DRB Project Number: 1011565  
City Realty Company Addition

SUBJECT: Sketch Plat

DRB Project Number: 1011565 Hearing Date: 03-21-2018  
 Project: 2900 & 2908 3<sup>rd</sup> St NW Agenda Item No: 12

Project: #1011565 18DRB-70083

Sketch Plat

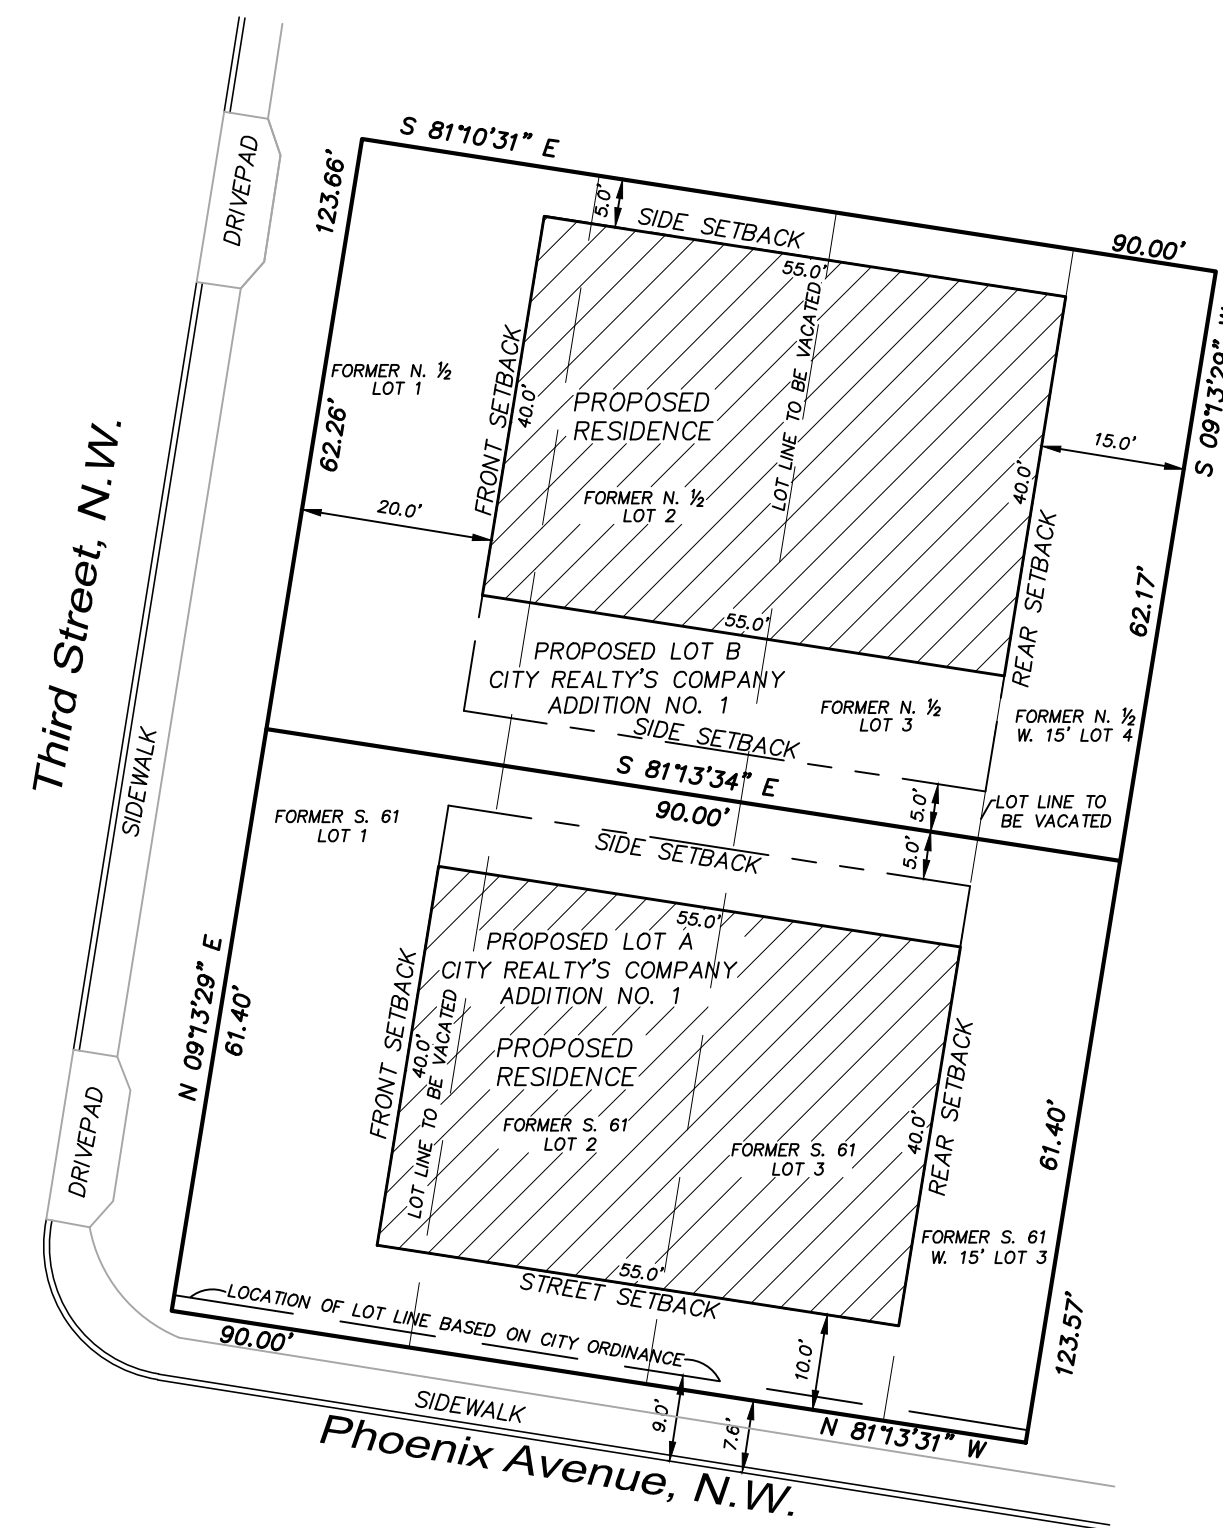
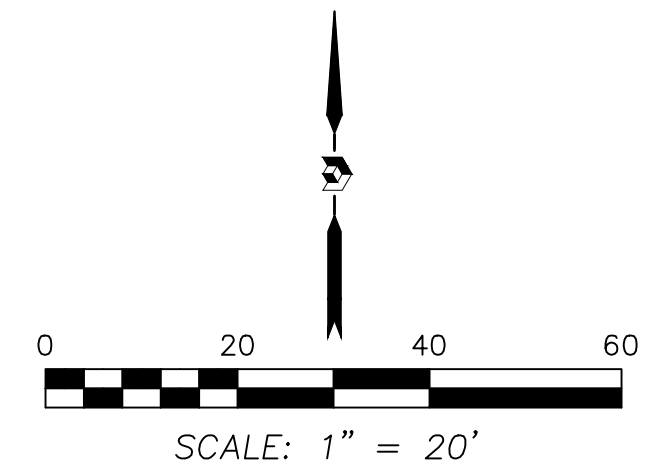
1. Provide a sidewalk exhibit showing the location, width, and defining the distance from back of curb to the property line. Right of way dedication may be required.
2. What are the uses of this development? A TIS or Trip Generation Exhibit may need to be provided.
3. If future development is not going to be submitted to DRB, a TCL (Traffic Circulation Layout) will be required before building permit.

*- Need curve on corner dedicated*  
*- Clarify lot lines*

- An approved “G&D Plan” will be required prior to Preliminary Plat and must include an onsite pond for each lot that will limit the peak rate of discharge to 0.1 cfs/acre and a “Private Facilities Drainage Covenant” for the maintenance of the ponds.
- A note should be added stating the source of floodplain information.

Property is currently Zoned R-1 or SU-2 NFTOD. As this action is not development that requires the Overlay Zone standards, the lots must meet the underlying Zone requirements. R-1 requires 5,000 Sq/Ft of lot area and a minimum lot width of 50 feet, the minimum standards do appear to have been met.
